07 March 2018

On 2 February 2018, the Department of Planning & Environment requested the Government Architect NSW (GANSW) to provide independent design review advice on application SSD 8440 a Mixed Use development located at 42 Honeysuckle Drive, Cottage Creek Precinct, Newcastle in the Newcastle local government area. In conducting the review, GANSW has considered the architectural drawings, landscape architectural drawings, the EIS and its appendices.

**COMMENTS IN RESPONSE TO STATE SIGNIFICANT DEVELOPMENT APPLICATION SSD 8440
42 HONEYSUCKLE DRIVE, NEWCASTLE**

2.3 BUILT FORM:

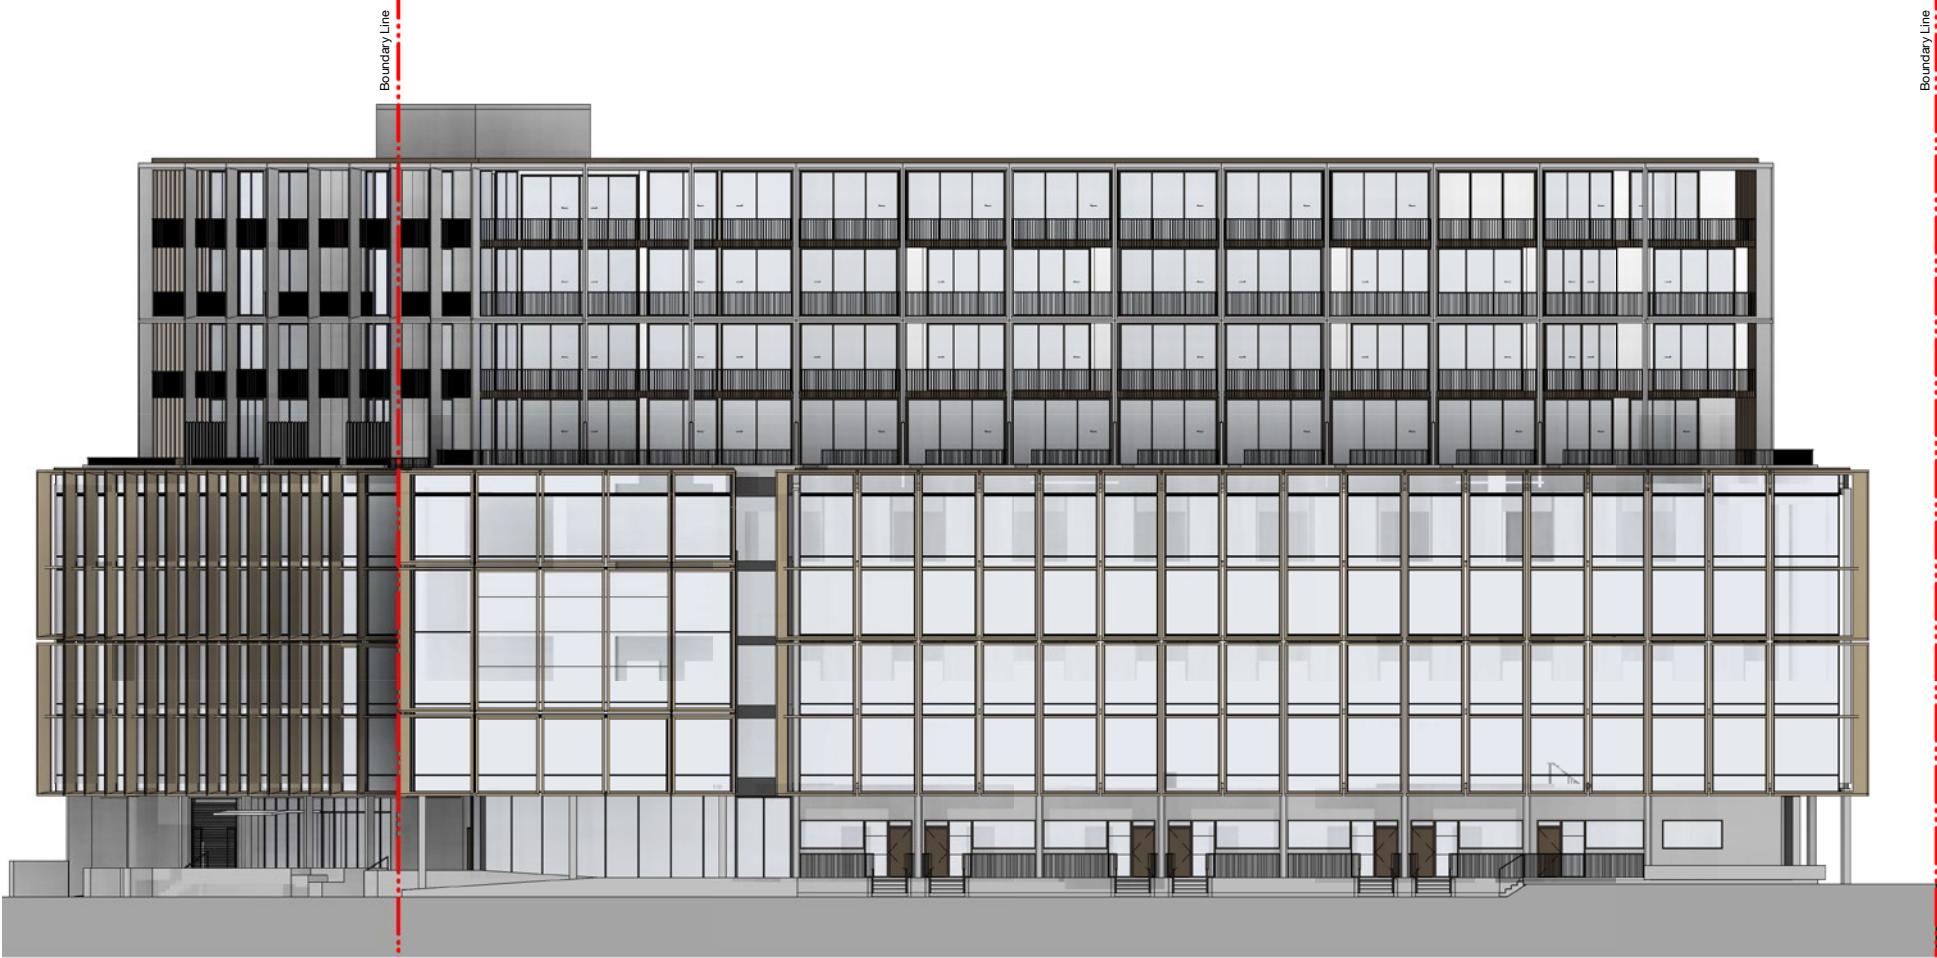
- The proponent should propose strategies for screening private external drying areas and storage zones from the public domain. Alternative communal facilities could also be considered including communal drying areas or drying rooms.

The use of transparent balustrades is supported however consideration should be given to screening of external drying areas and storage zones from the public domain. Alternative communal facilities could also be considered including communal drying areas or drying rooms.

1 Southern facade planters and green facade on GF-Typical
Scale: 1:50

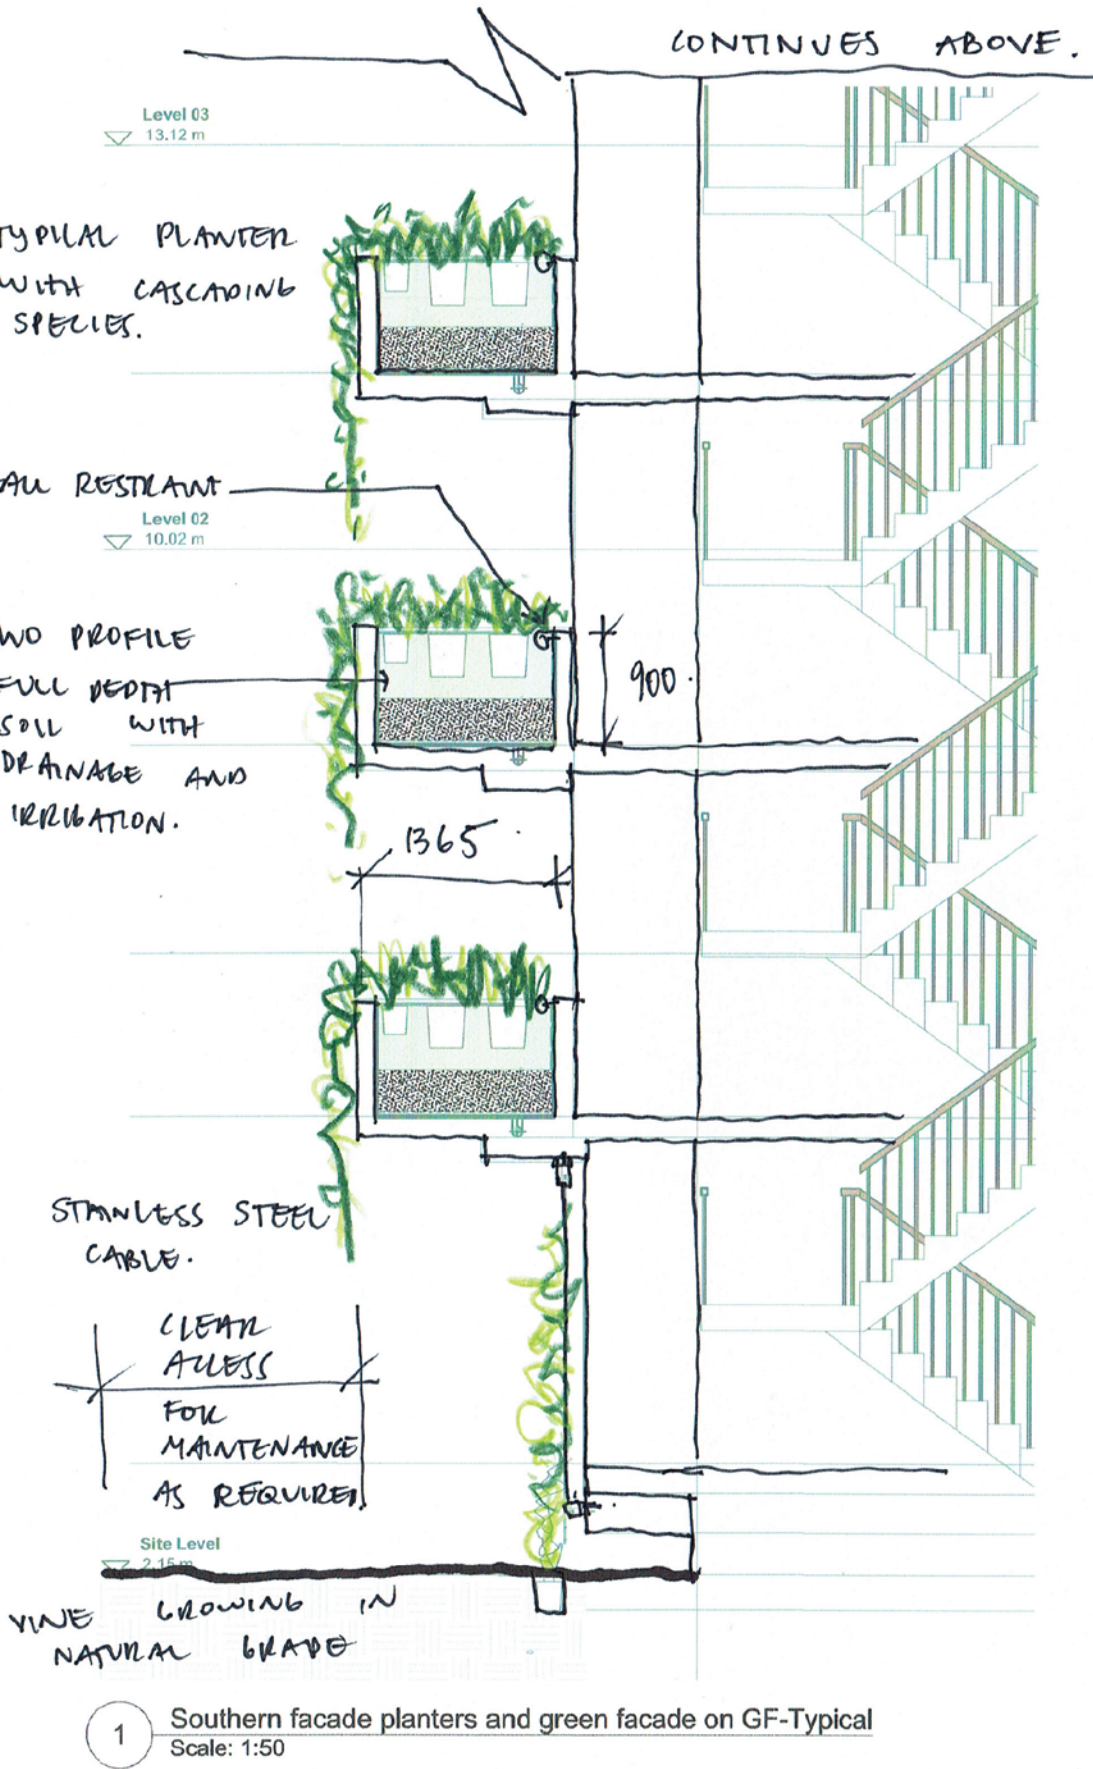
- Provide a design verification statement from a green wall expert to ensure suitability of the system proposed.

The robust material palette and detailed landscaping including vertical green walls is supported. GANSW request a design verification statement from green wall expert to ensure suitability of the system proposed.

4.2 HOTEL COMPONENT VENTILATION

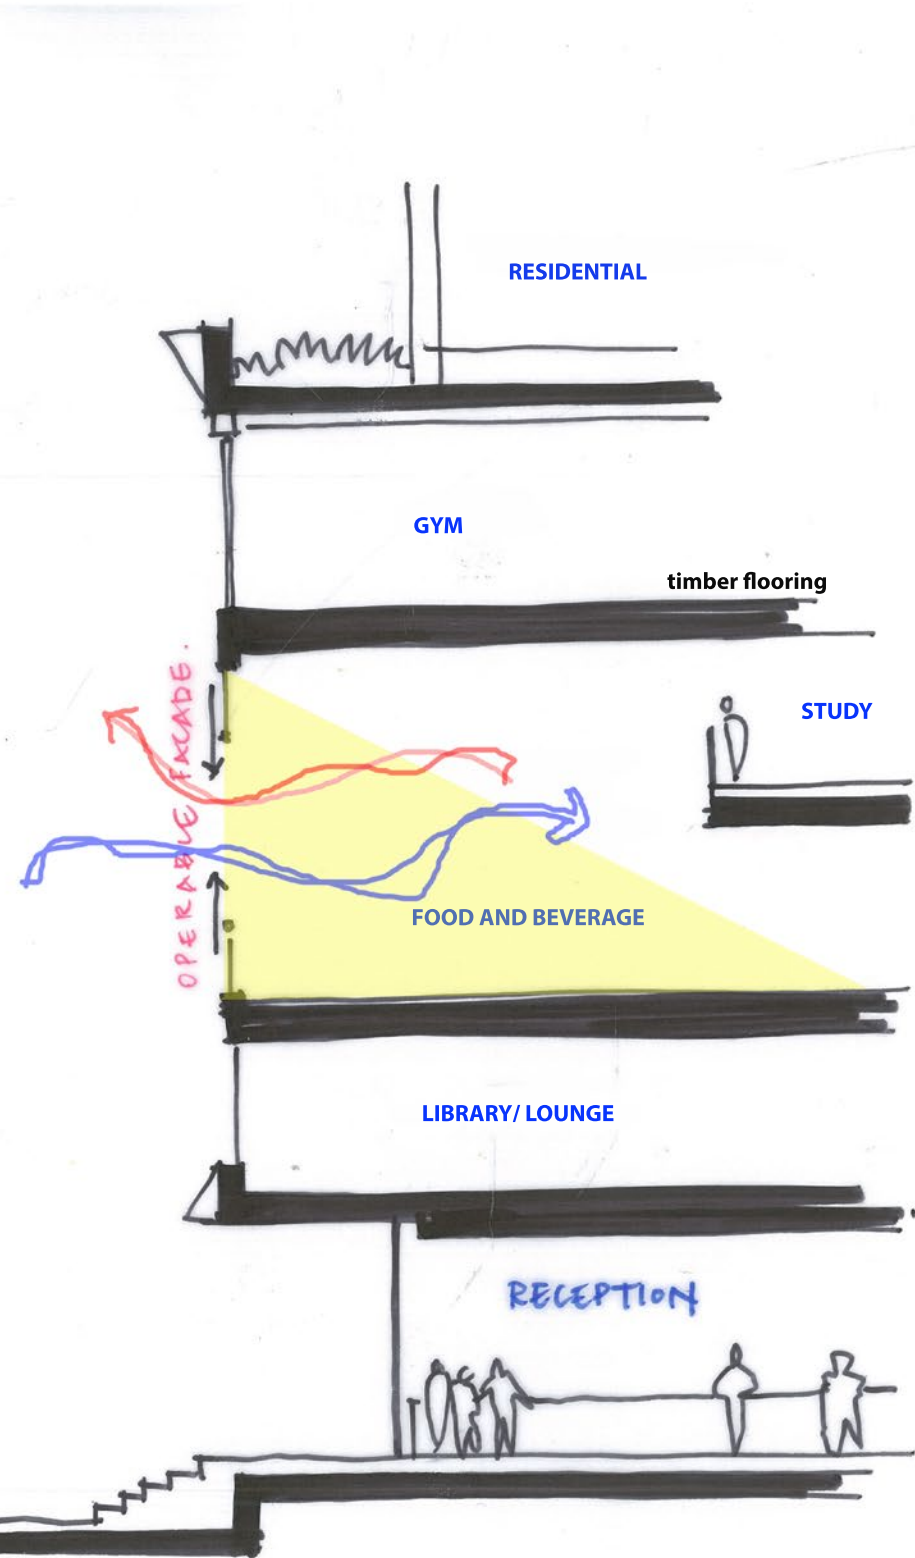
- Provide the opportunity for natural ventilation to the hotel rooms and communal hotel spaces including lounge, gym and food and beverage areas.
- The proposed Sustainable travel guide should be developed within the operational strategy for the site.

Passive thermal design strategies are acceptable including proposed natural ventilation to all carparking areas and residential apartments however further consideration should be given to providing natural ventilation to the hotel rooms and communal hotel spaces including lobby, lounge, gym and food and
